May 15, 2024

**Re: Oxbow Center Subdivision (Private Utilities and Roadway) at 3901 Coors Blvd. NW
Erosion and Sediment Control Plan
Engineer's Stamp Date 5/8/24 (G11E067)**

Based on the information in your submittal, received on 5/8/24, the above-referenced ESC Plan cannot be approved for Grading and Paving Permits until the following comments are addressed.

ESC-3

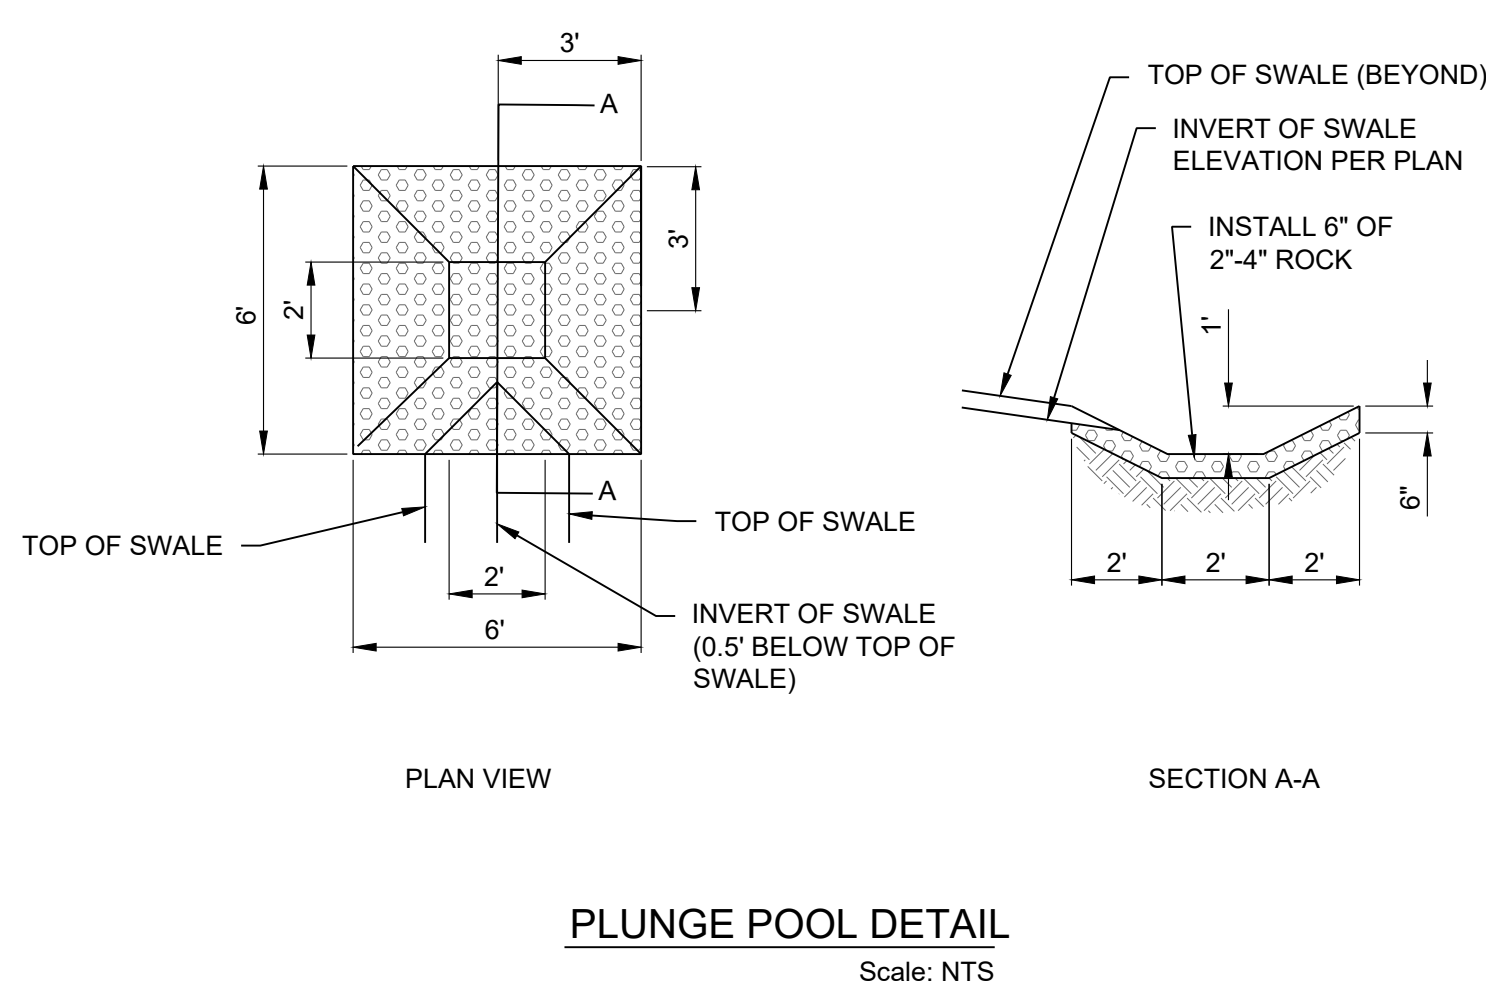
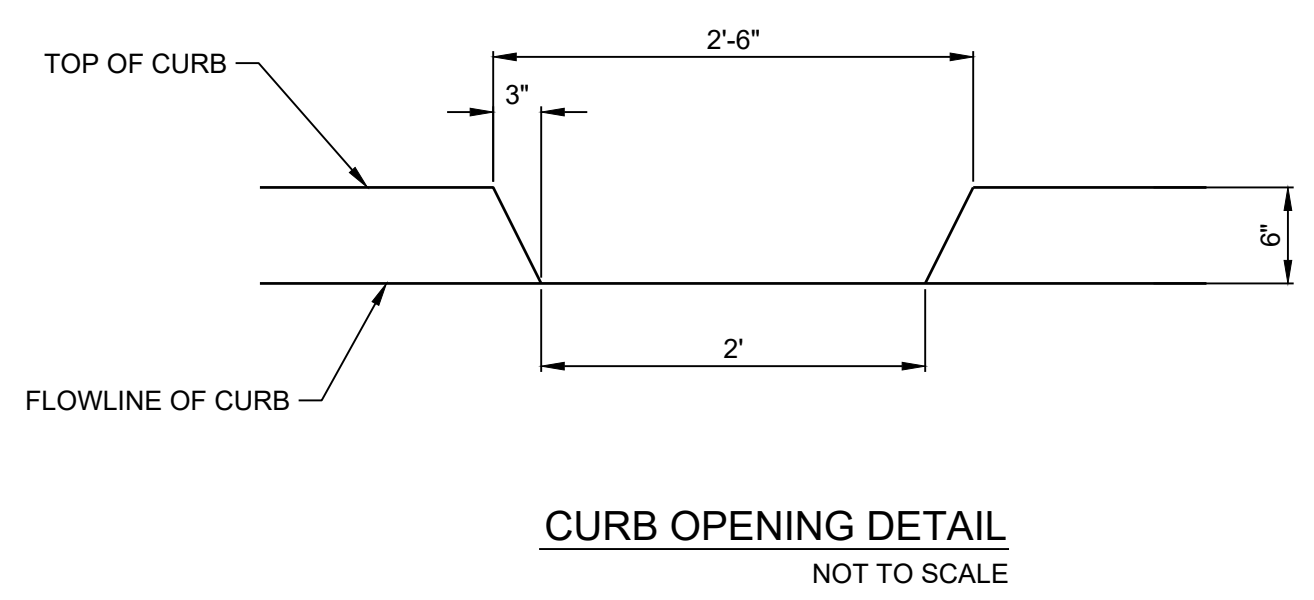
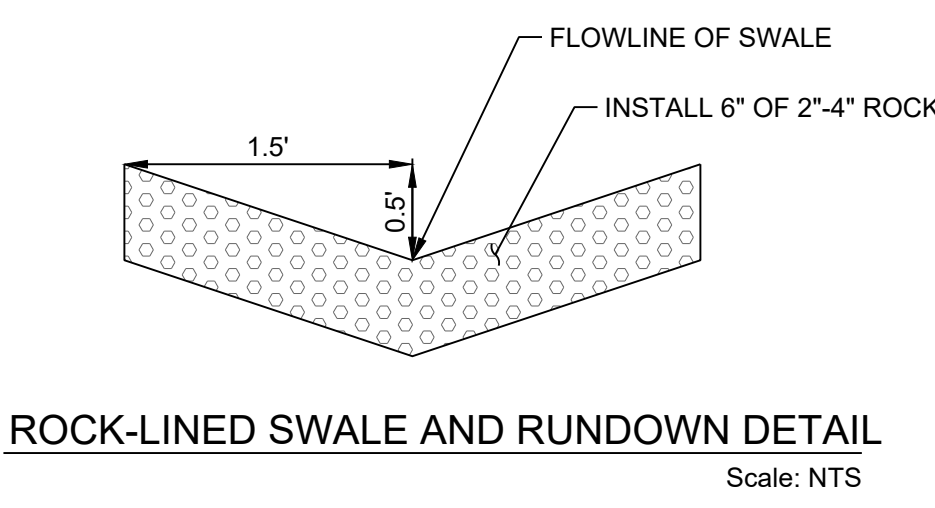
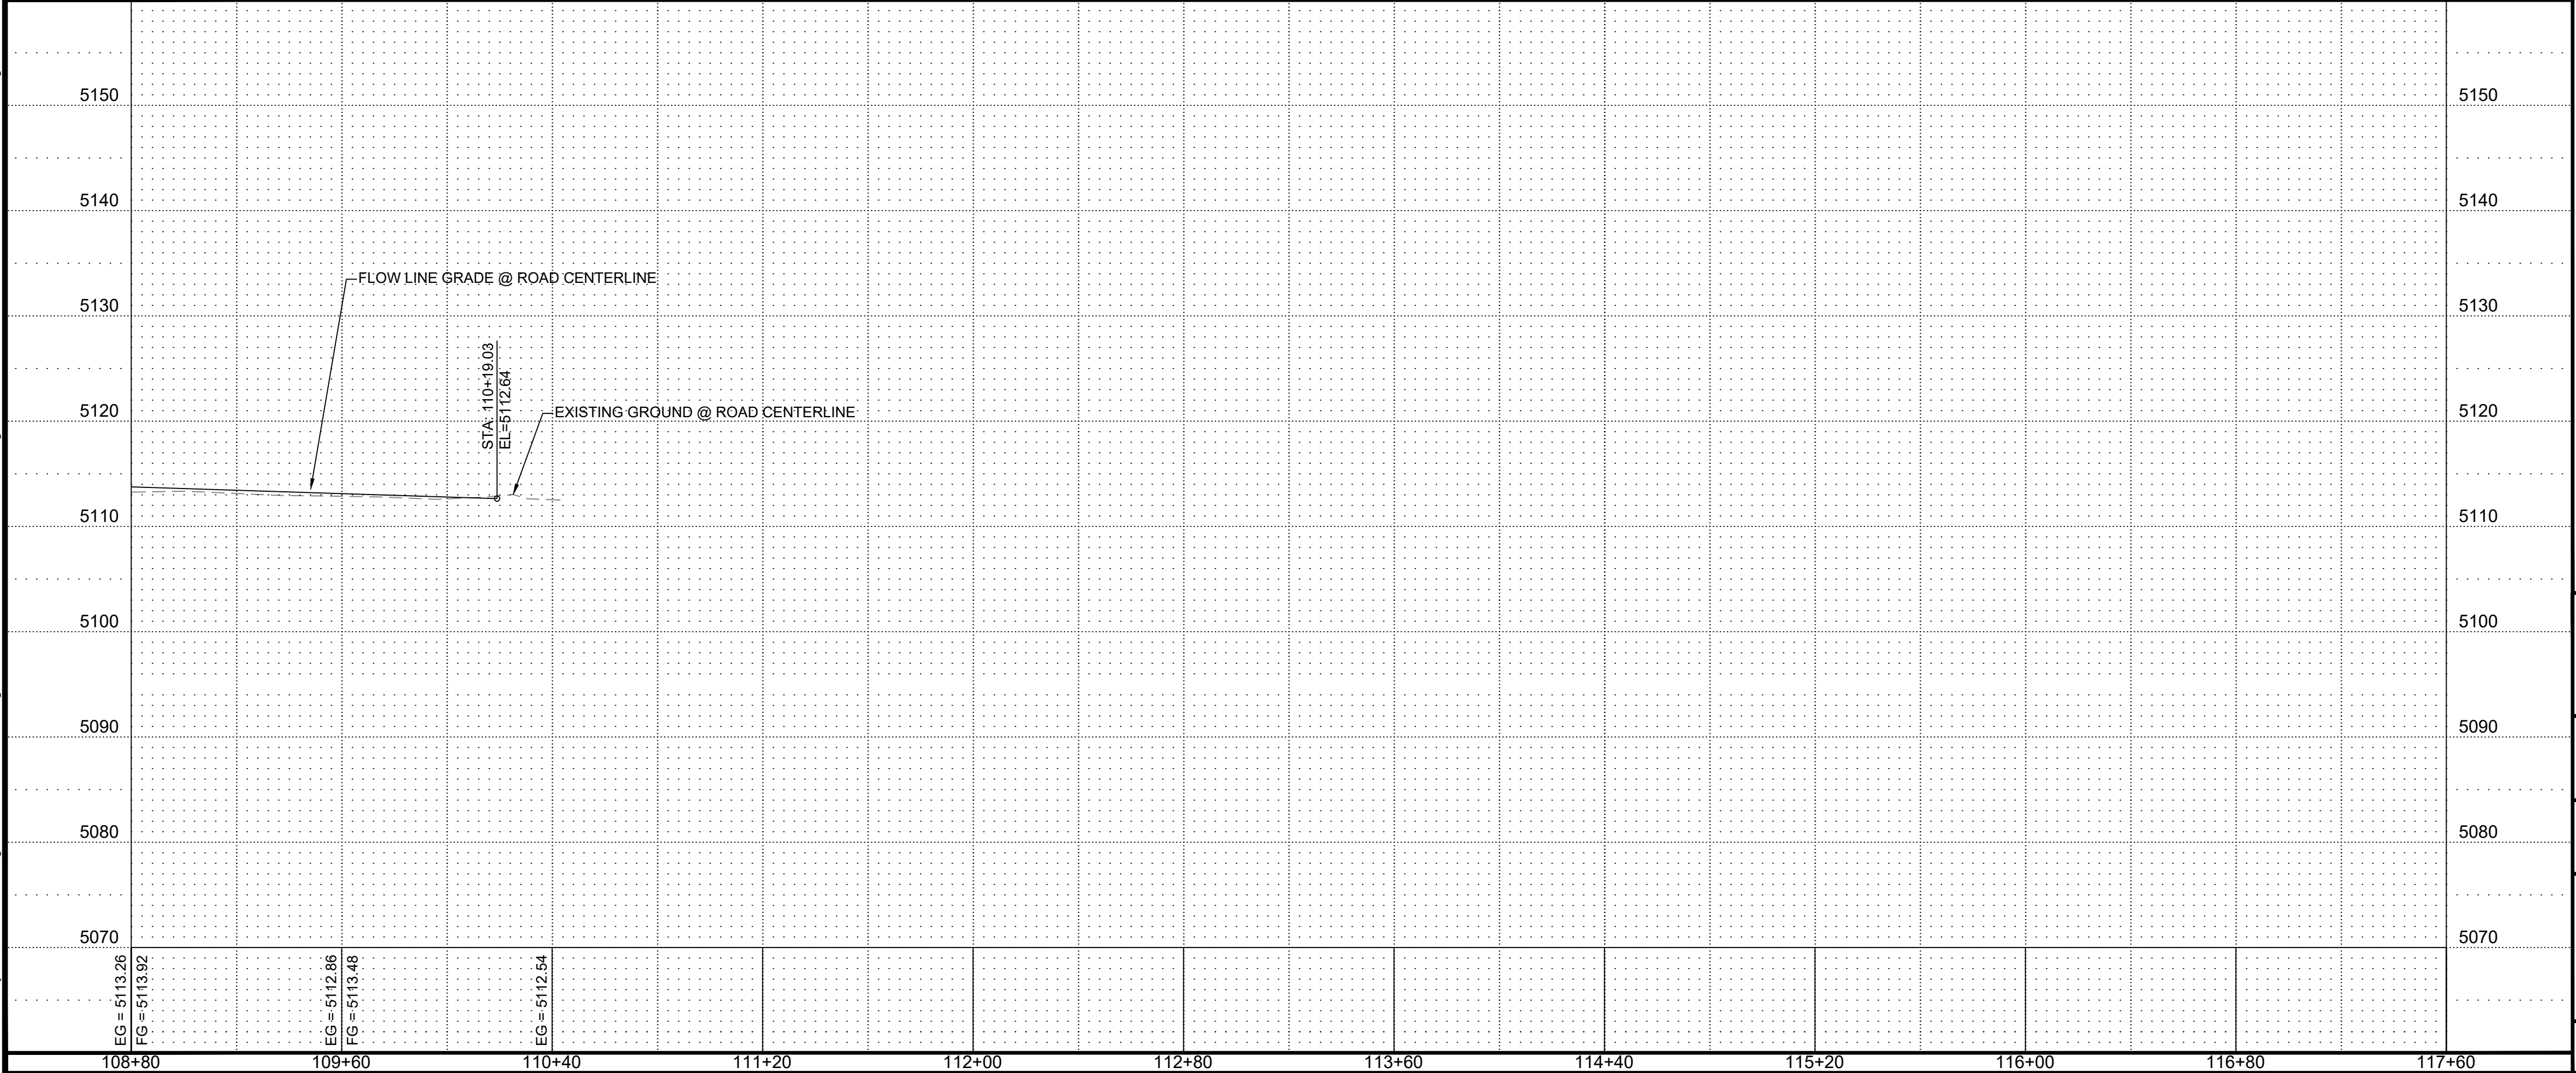
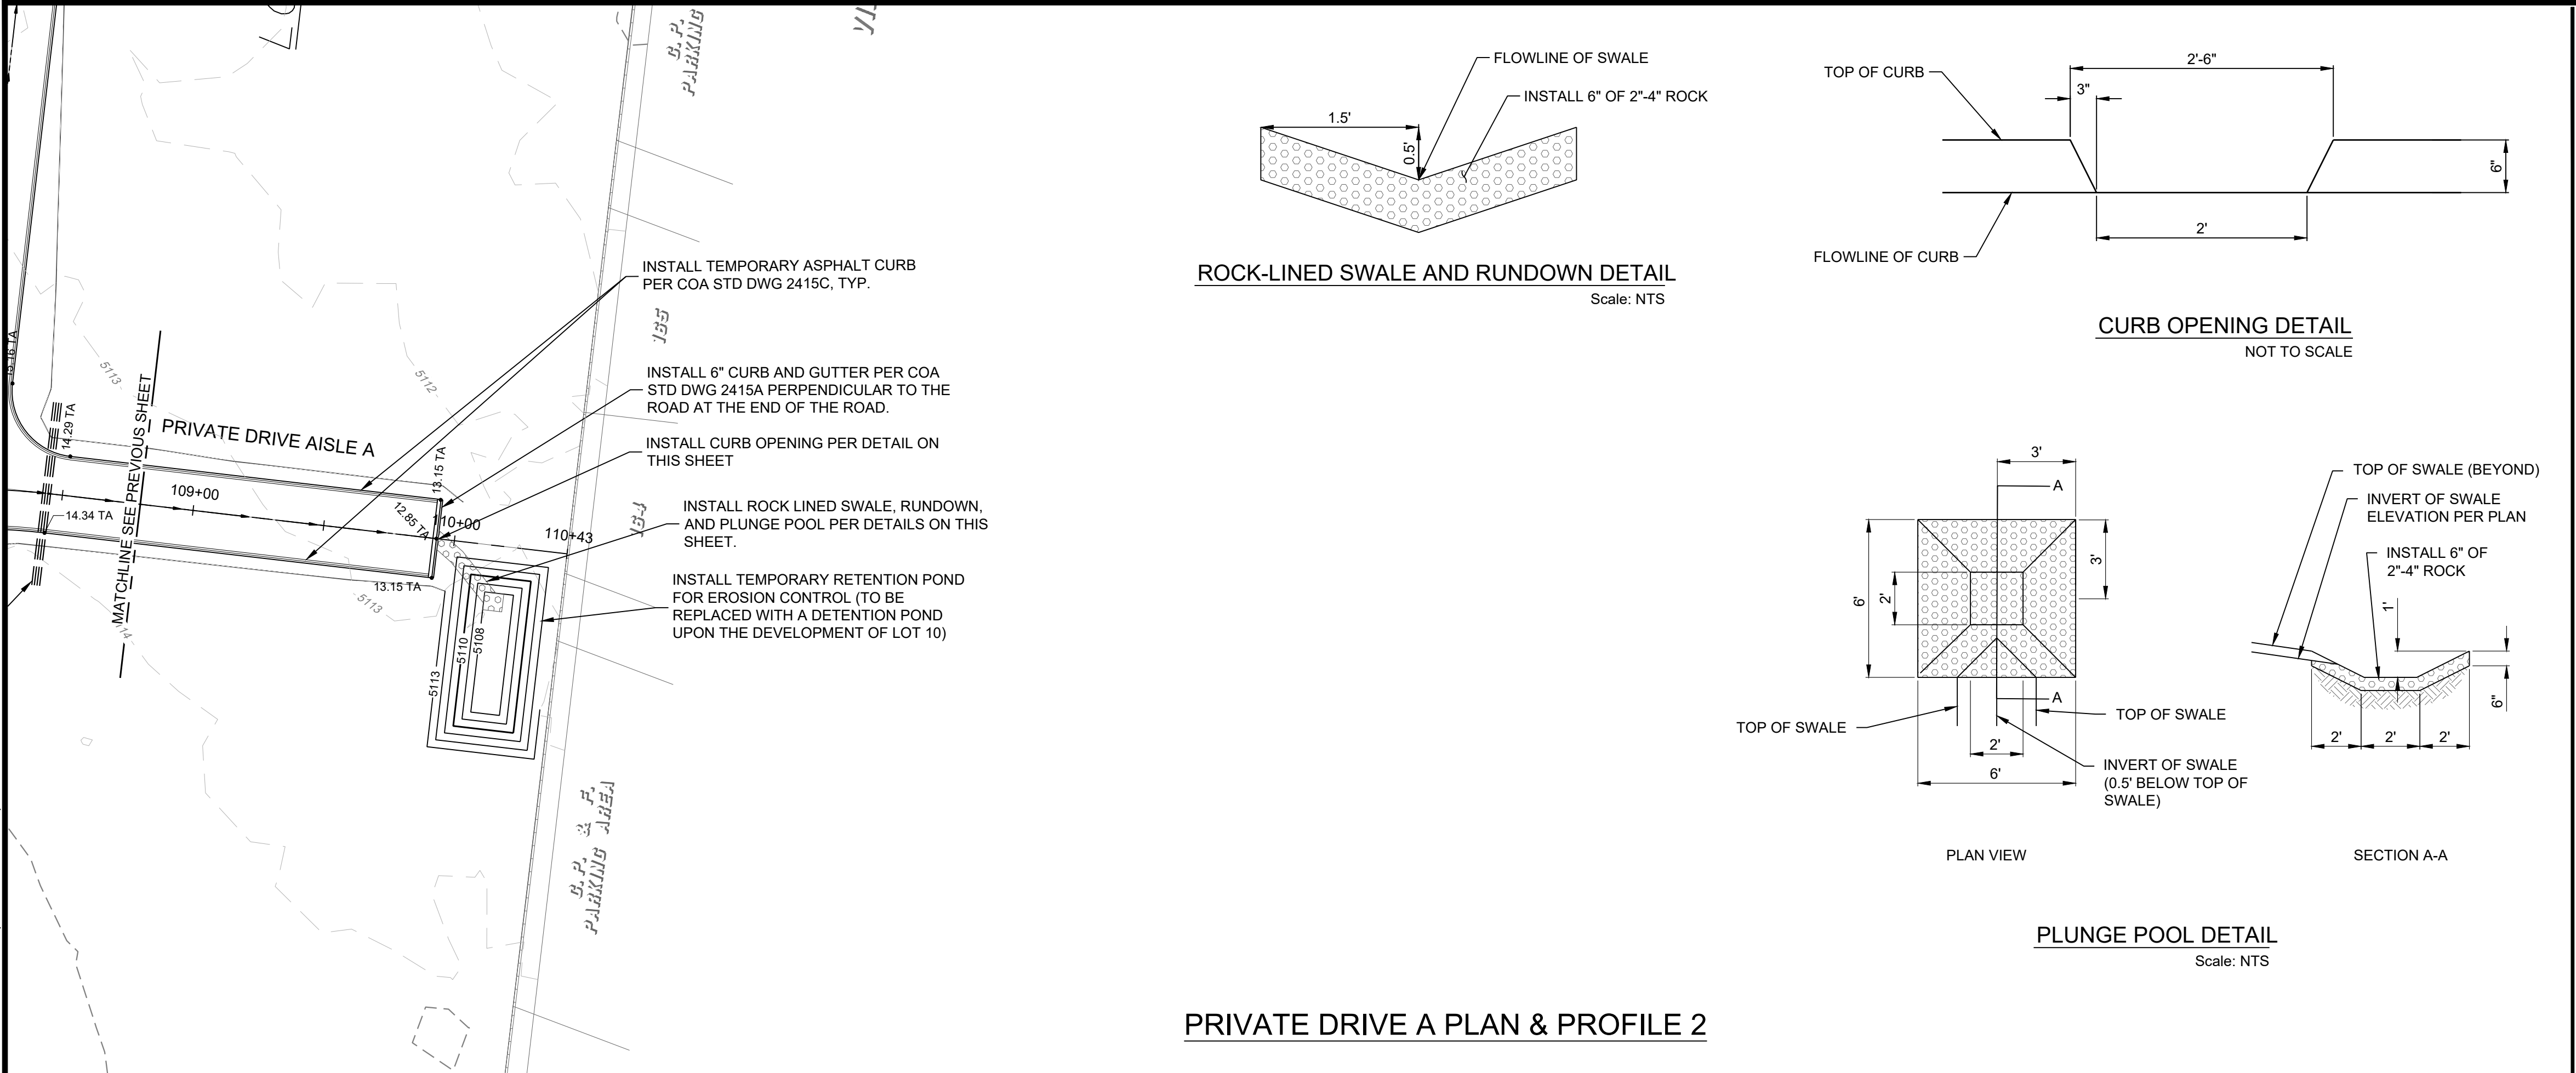
2. The Schedule on sheet ESC-3 mentions three phases. The interim phase includes "Building" and "Mass grading," but no buildings or mass grading are shown on the Grading Plan approved by Hydrology or on this ESC Plan. So, remove buildings and mass grading from the schedule. The schedule must address the beginning and end of each phase. It must include all phases needed to complete the development of this 29.2-acre Common Plan. Identify the area of land-disturbing activities for each phase. The schedule must include but not limited to:

- i. The Onsite Private Utilities and Roadways and associated land disturbance.
 - ii. The Onsite Public Utilities and associated land disturbance.
 - iii. The Offsite Public Infrastructure (about 3.3 acres including 0.53 acres additional ROW dedicated with this plat)

- iv. The Onsite Public Pond in the northwest corner and grading at the existing pond.
 - v. BMPs for preserving the existing vegetation on the lots and transferring any of the lots to other owners/operators.

- vi. The completion of Construction and Stabilization before removal of BMPs and before connection to any downstream stormdrain.
3. The scale of the ESC Plan is missing. Include a graphic scale and north arrow on each sheet. A scale of 1"=50' is suggested. The scale must be adequate to show the improvements and BMPs clearly. More than one sheet may be needed. All phases must be shown clearly.
